KITTITAS COUNTY COMMUNITY DEVELOPMENT SERVICES

March 25, 2019

Subject: Ranch Road Performance Based Cluster Plat (LPF-19-00002) Final Plat. – Staff Review and Request for Additional Information

PROPERTY INFORMATION:
 PARCEL NO.: T1706, T1704, T1703, T1702 & T1701
 SECTION 28, T17N 03N E02W, S17-28020-000, S17-28030-000, S17-28040-000 & S17-28050-000
 COUNTY: KITITAS COUNTY, WASHINGTON
 ZONE: M-3
 DISTRICT: 1
 COUNTY: 1
 DISTRICT: 1

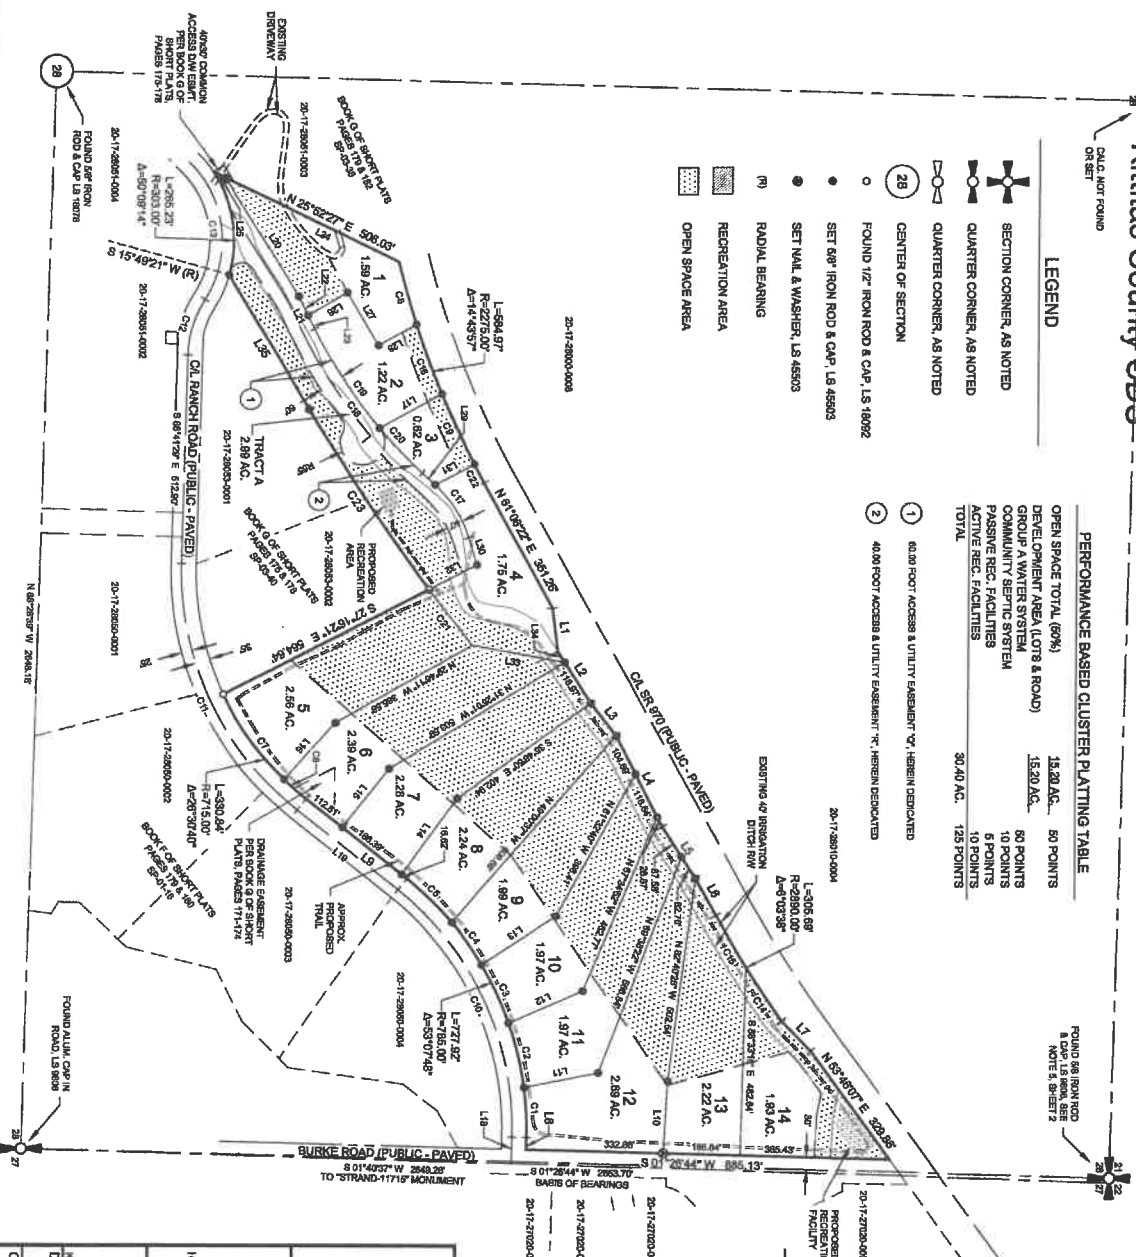
- 1) The zone is given as “Ag-3” on sheet 2. The zoning information must be updated to reflect the current zoning of the subject property, which is Agriculture 20.
- 2) Under “Approvals” on sheet 3, ‘Ranch Road Cluster Plat’ is used to refer to the subdivision. Please revise this to reflect the full name of the project: “Ranch Road Performance Based Cluster Plat”.
- 3) Current 2019 taxes must be paid in full on all parcels.

INDEX LOCATION
SEC. 28 T. 20 N.R. 17 E. W.M.
SHEET 1 OF 3

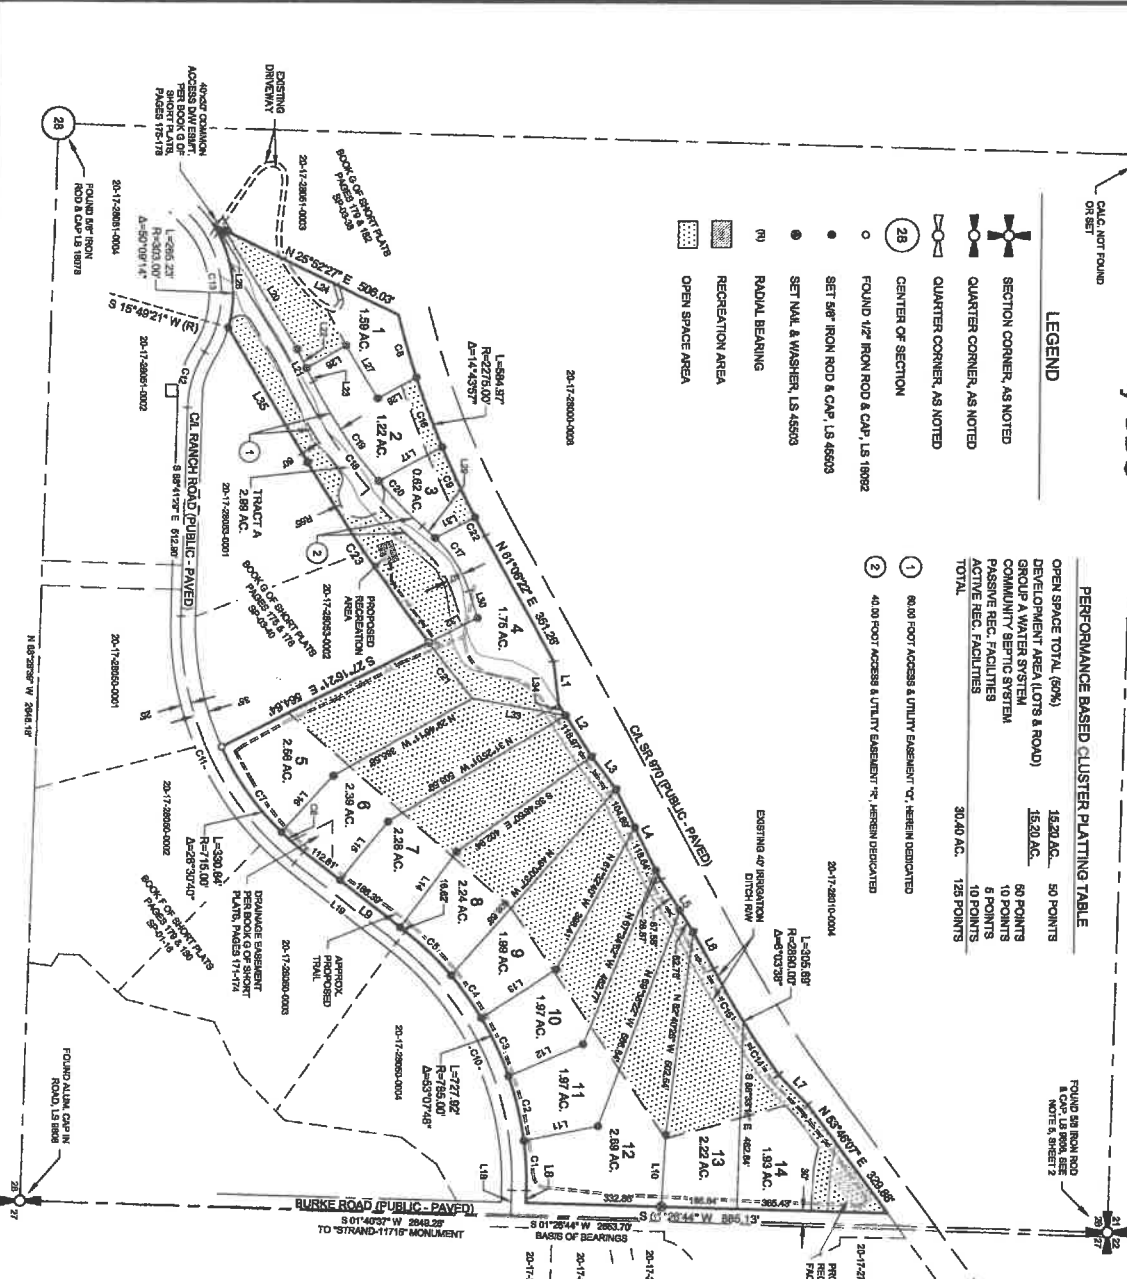
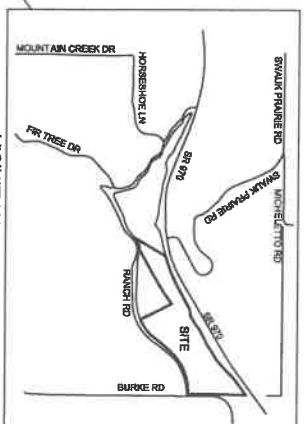
Sheet 1:

- 1) The dimensions for the North line of Lot 13, and the Northeast line of Lot 8 are obscured by crossing linework.
- 2) The division line between lots 13 and 14 should be monumented in the field.

- 3) The ownership of the public right of way should be clarified as being county or state.
 - a. EX: “Burke Rd- County R/W –Paved”
- 4) The open space limits are not retraceable/locatable.

- 5) The existing driveway serving lot 1 should include reference to the 20 foot access easement recorded under AF 2019031300003.
- 6) The access easement serving lots 2, 3, and 4 should be shown as dedicated right of way OR clear language included on the face of the plat that the entirety of Tract A shall fall under the ownership of a homeowners association, so as to protect the county from undesired ownership through absentee land tax.
